67 Merrill St Inbox x

**Ann Machado** Jon - I'm moving the permit forward to building for the code review. I need

SEC E-E

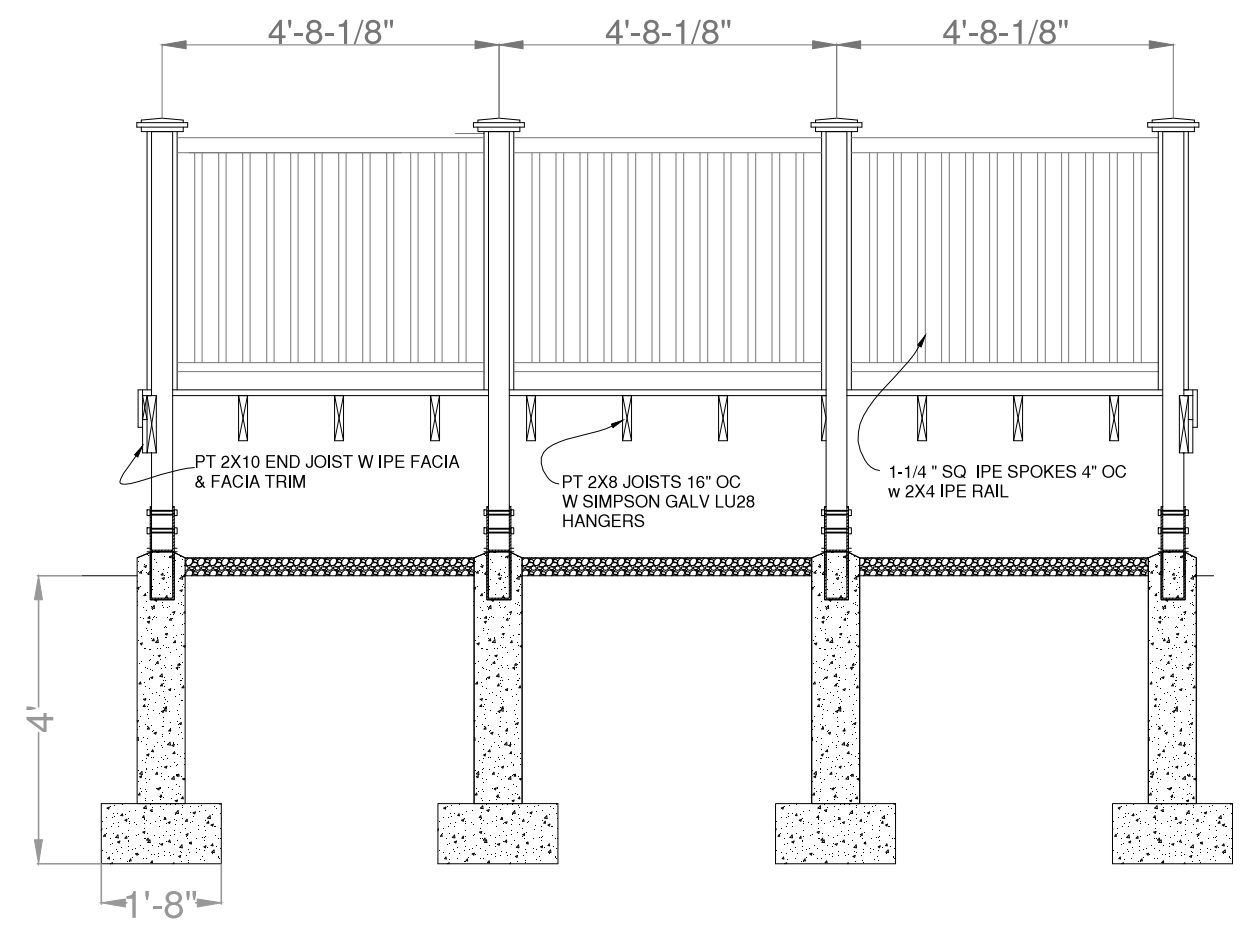
I left a message in your voicemail yesterday regarding the grade. There is not a grade cut floor to accommodate the correct rise and run for the front stoop.
